**Consultation Response from KC,
Ecology Unit**

2023/90945 adj, 9, Hyrst Gardens, Batley, WF17 7EH

Erection of detached dwelling

Date Responded: 26/04/2023

PLAN 2 OF 3	
Scale	1:250@ A3
Plan Title	Tree Impact Plan
Site	Off Track Rd, Batley
Date	7.2.23
tree@treeplan.co.uk

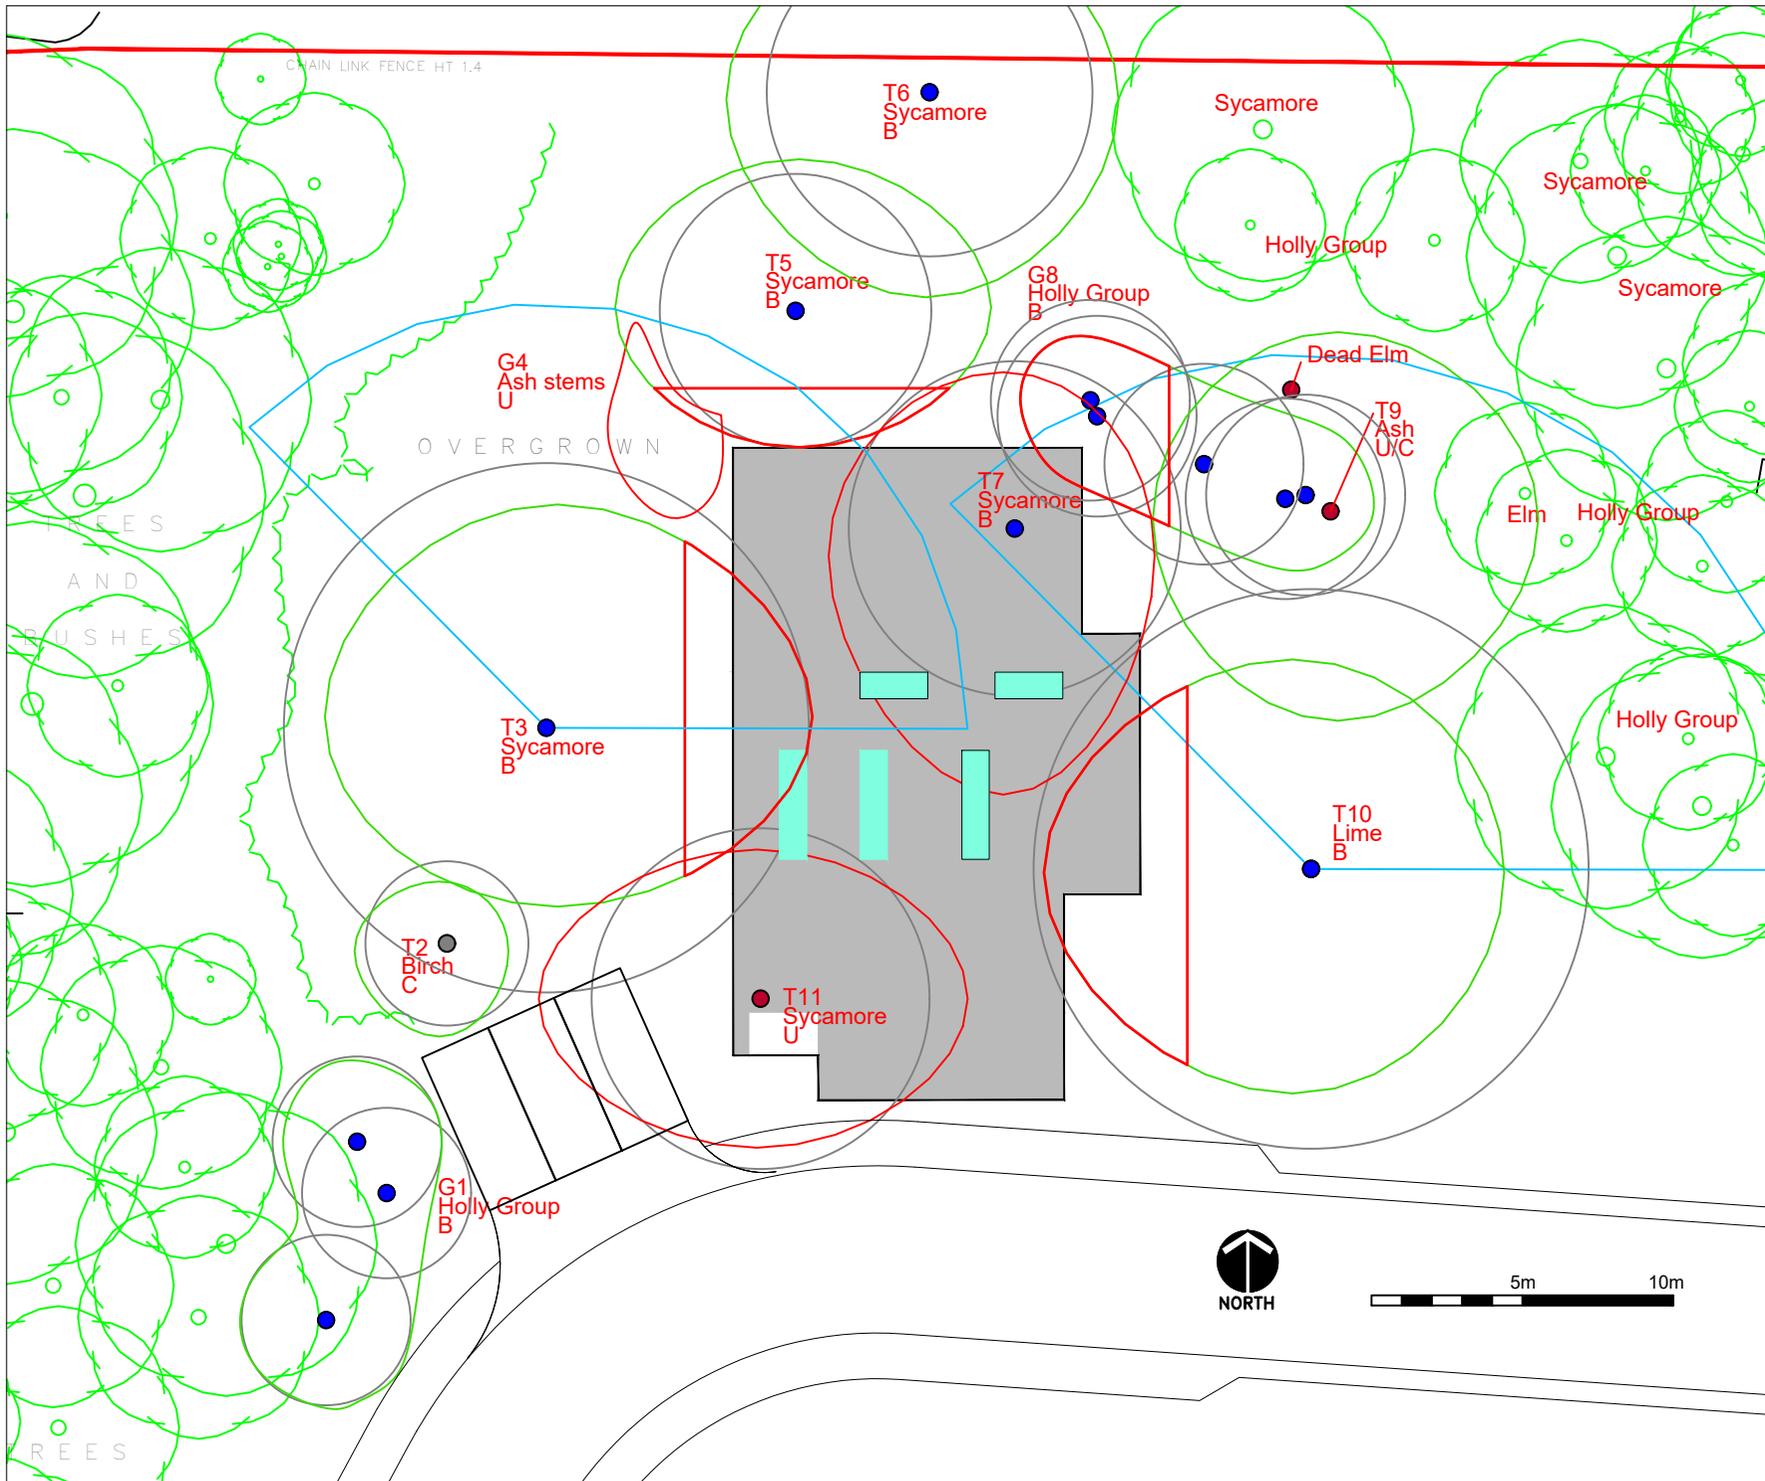
No ecological information has been submitted along with the application; therefore, the assessment of the ecological impacts is based on the limited information available. The site is located within the bat alert zone. Therefore, as the surrounding area provides suitability for bats and the proposals include the removal of trees at the site, there is a reasonable likelihood of disturbance to roosting bats.

The applicant should engage with a suitably qualified ecologist to undertake a daytime inspection for bats (also known as a Preliminary Roost Assessment or Bat Scoping Survey). In many cases this will be adequate to determine whether bats are likely to be affected. If the survey indicates that further activity surveys are required to determine the presence/likely absence of bats, this information should also be supplied. Bat activity surveys should be carried out between May and August and in accordance with Bat Conservation Trust guidelines (Collins, 2016).

The application should not be determined prior to obtaining survey information regarding bats.
